Thank you for the opportunity to be able to comment on the response by the Applicant (EDF) to the questions from the Secretary of State as part of the DCO process for the proposed development at Sizewell C.

Response to Secretary of State 's Request for Information, 25th April 2022 from Bill Parker IP20026713

TR544: PRELIMINARY SCDF DESIGN  
NOT PROTECTIVELY MARKED

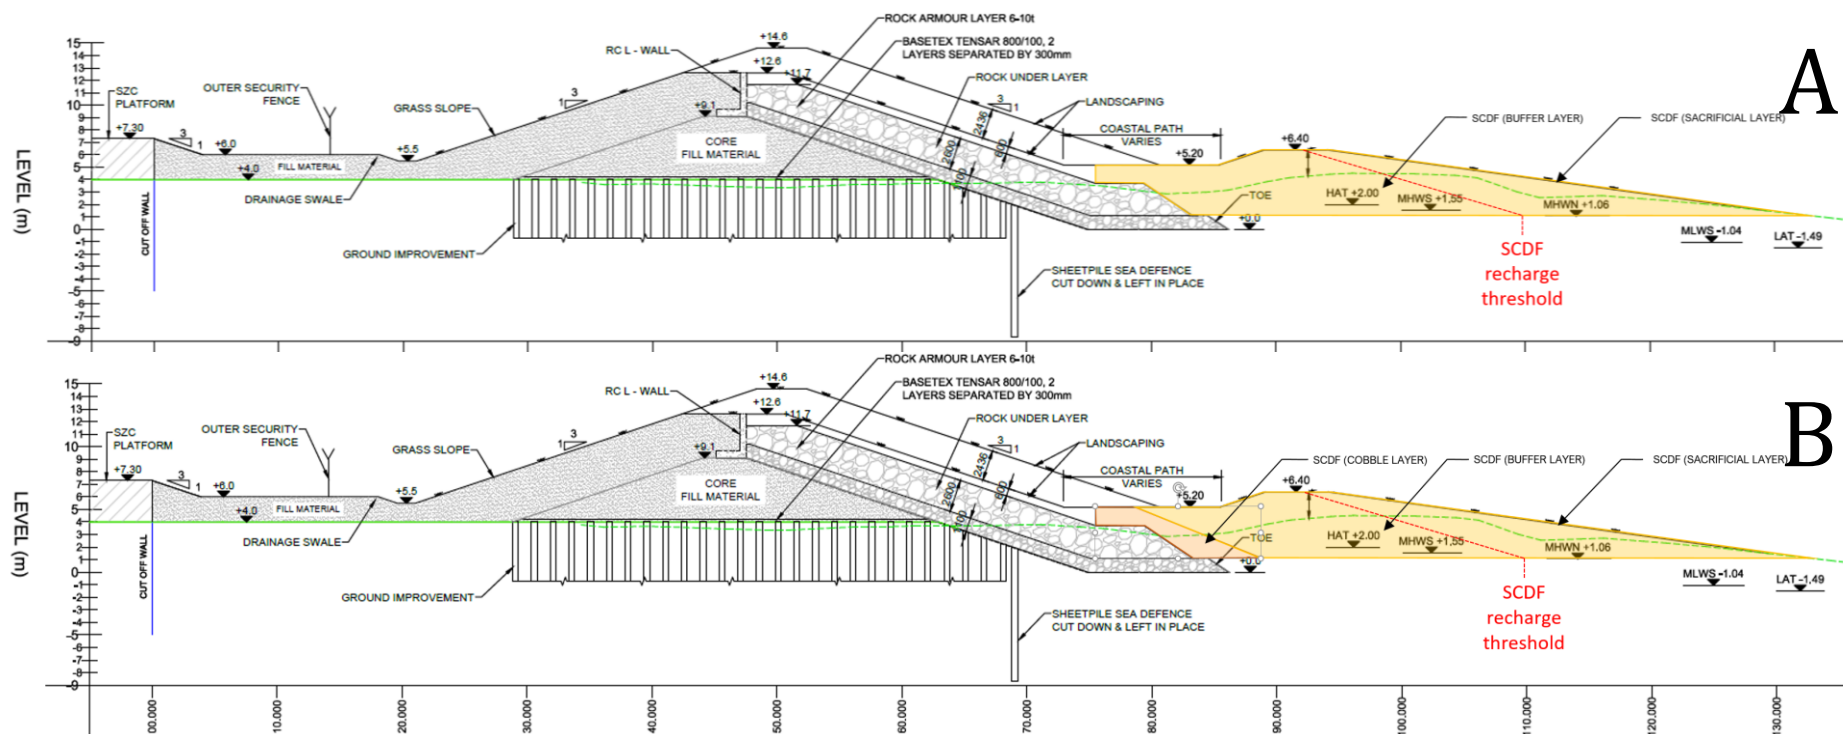
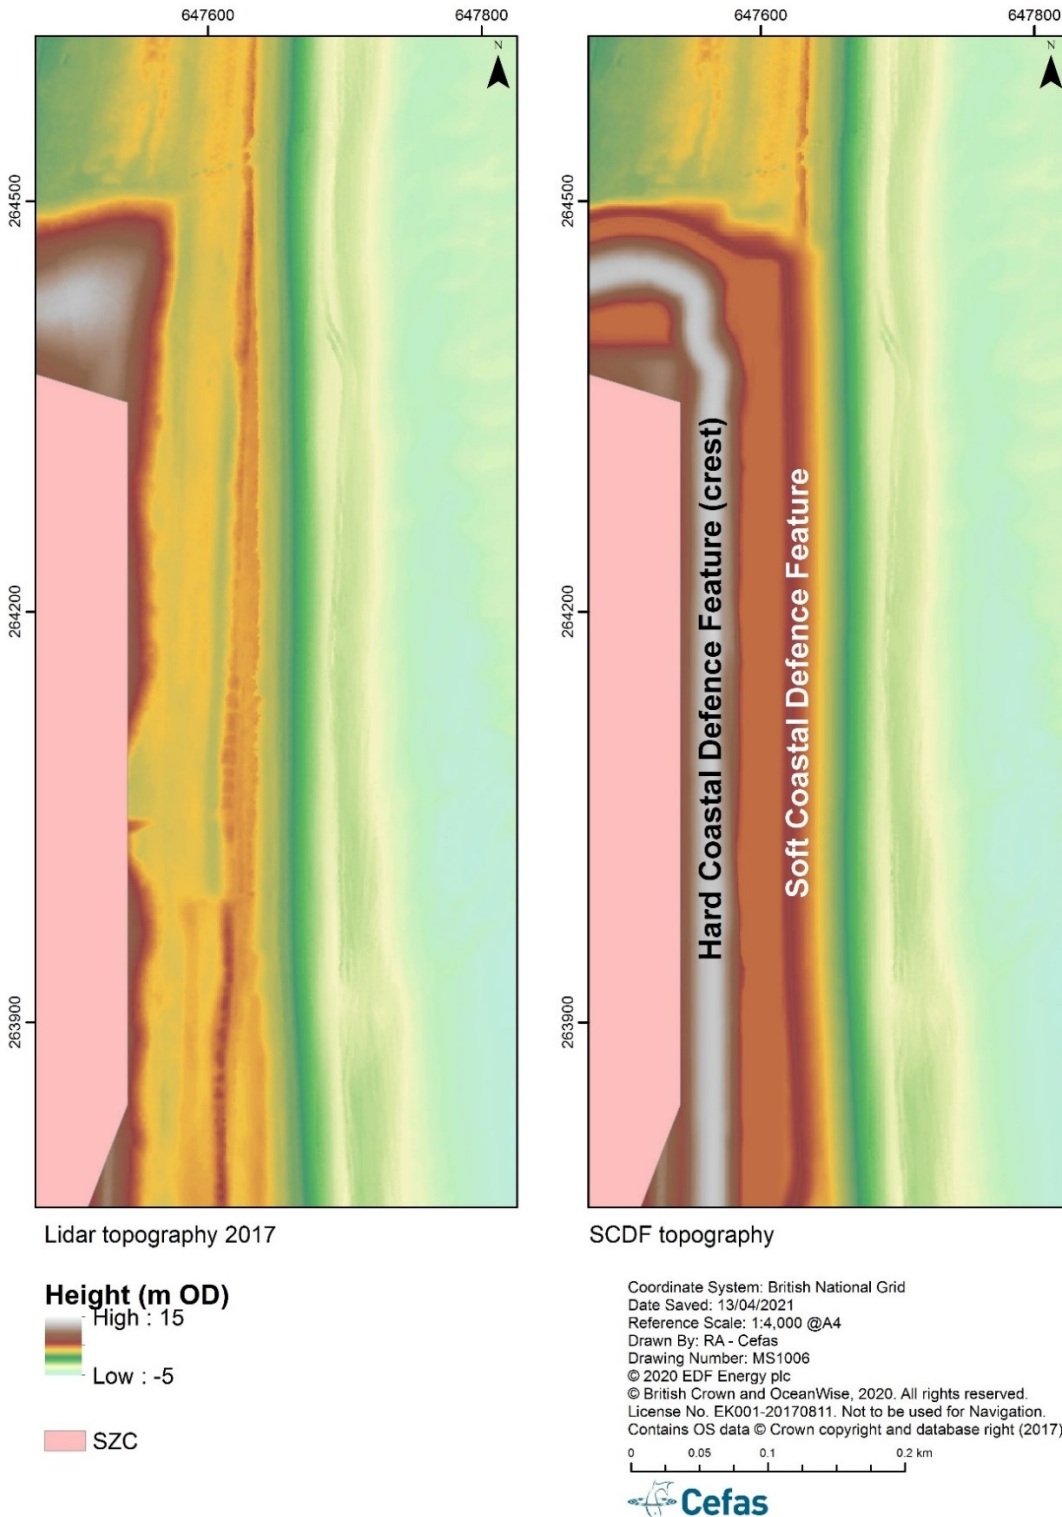
- Detailed Examination of TR544 highlights significant weaknesses in this paper. This has been examined in detail in a submission to this process by Nick Scarr but in summary:
 - EDF / CEFAS fail to take full account the likelihood of storms
 - EDF / CEFAS do not take into account in-combination events (storm and surge)
 - EDF / CEFAS fail to take into account the issues exacerbated by eroded coastlines
 - EDF / CEFAS analysis relies on a closed system of sediment movement, which is not universally scientifically agreed and its argument is empirically weak.
